**From:** [Howard Smith](#)  
**To:** [A303 Stonehenge](#)  
**Subject:** THE EXAMINING AUTHORITYS SECOND WRITTEN QUESTIONS ANSWER ON BEHALF OF P.J.ROWLAND AND SONS (FARMERS) LIMITED QUESTION CA.2.40  
**Date:** 24 July 2019 16:34:36

# Google Maps PLAN SHOWING EXISTING WIDTH OF PRIVATE TRACK INTENDED TO BECOME ALLINGTON LINK

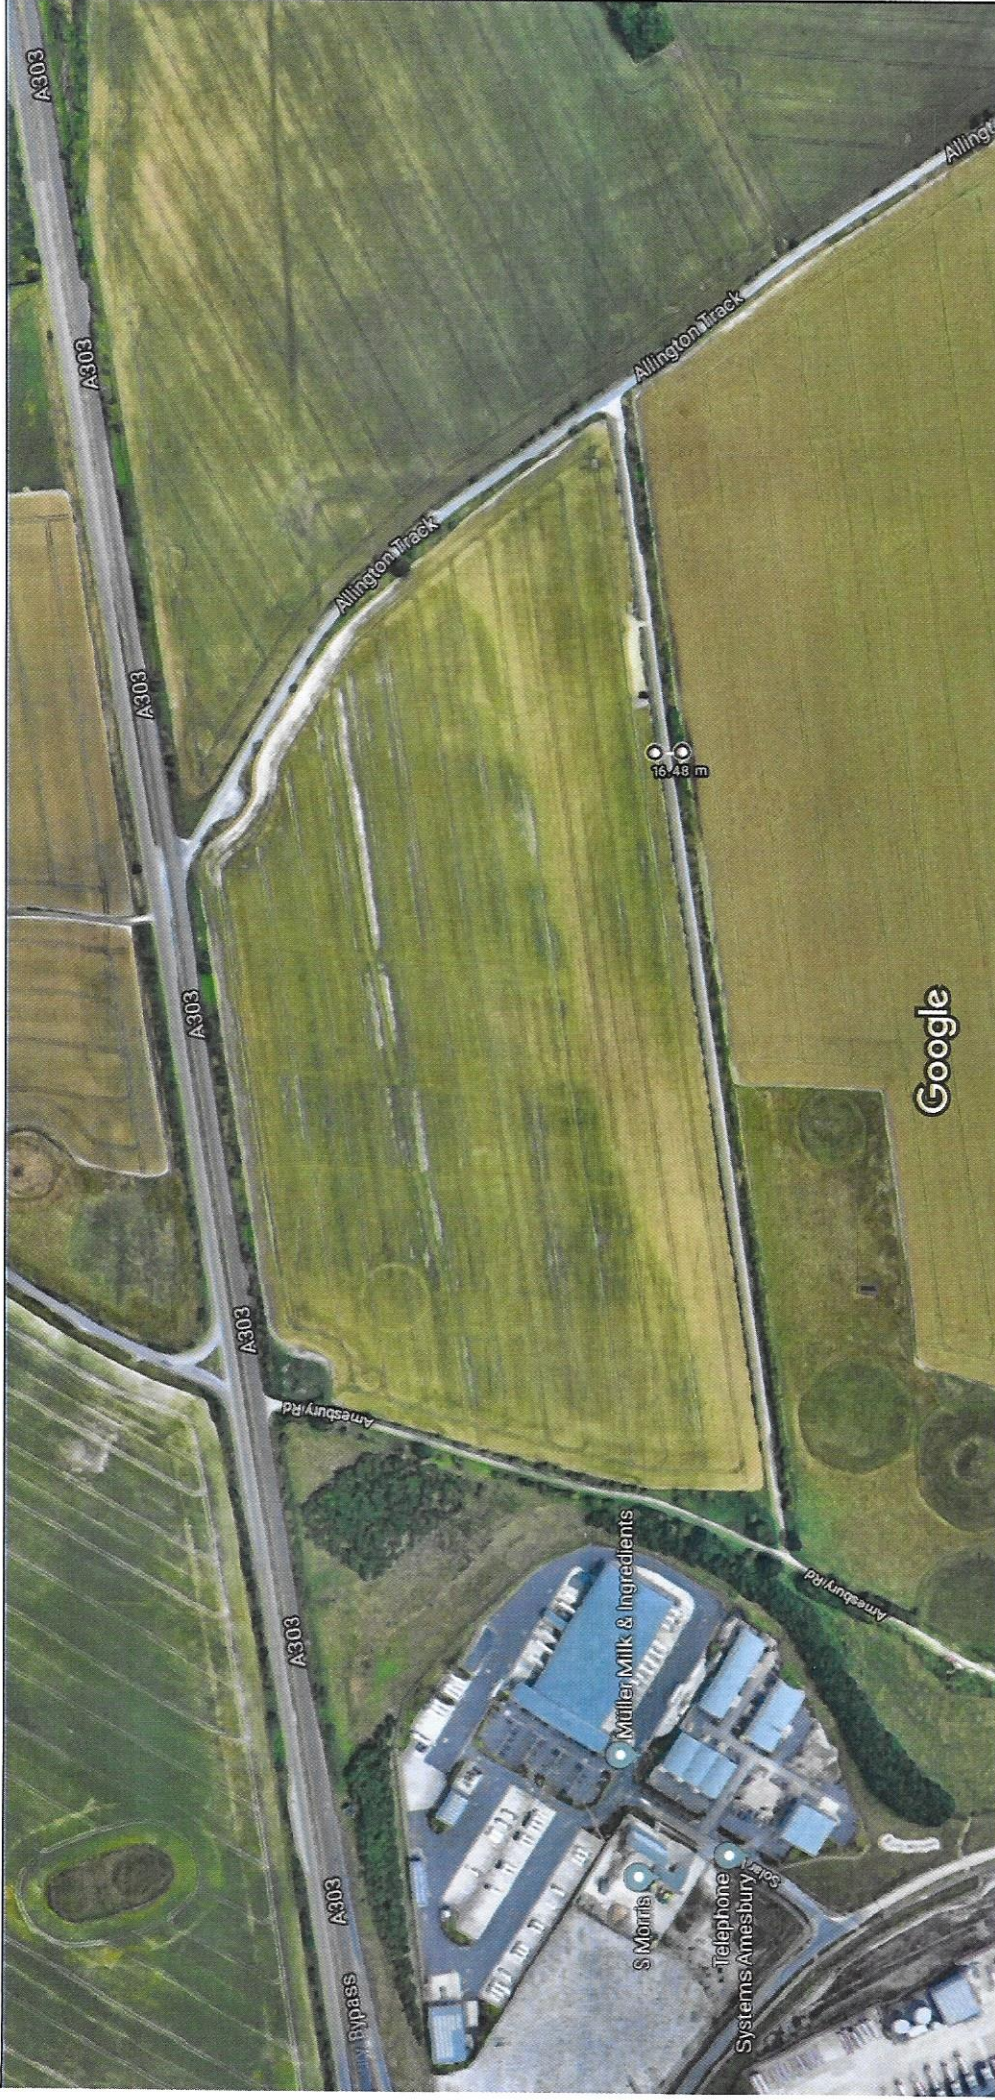
The applicant at the Compulsory Acquisition hearing put forward the suggestion that PLOT 11-09 was required to enable services to be installed presumably in the verge however no detail was provided as to what services these will be and therefore reliance on an all encompassing answer without sufficient detail is considered to be inadequate.

A similar answer was given to the same concerns raised by Beacon Hill Land and therefore it appears as if the verges either side of the new Allington Track will be inundated with services which have yet to be identified but takes no regard of the existing width of the current track, verges and hedges. The extent of the compulsory acquisition has no need to extend into the land my client is tenant of and should be limited to the area between the two existing hedges. The argument for requiring additional land is not proven.
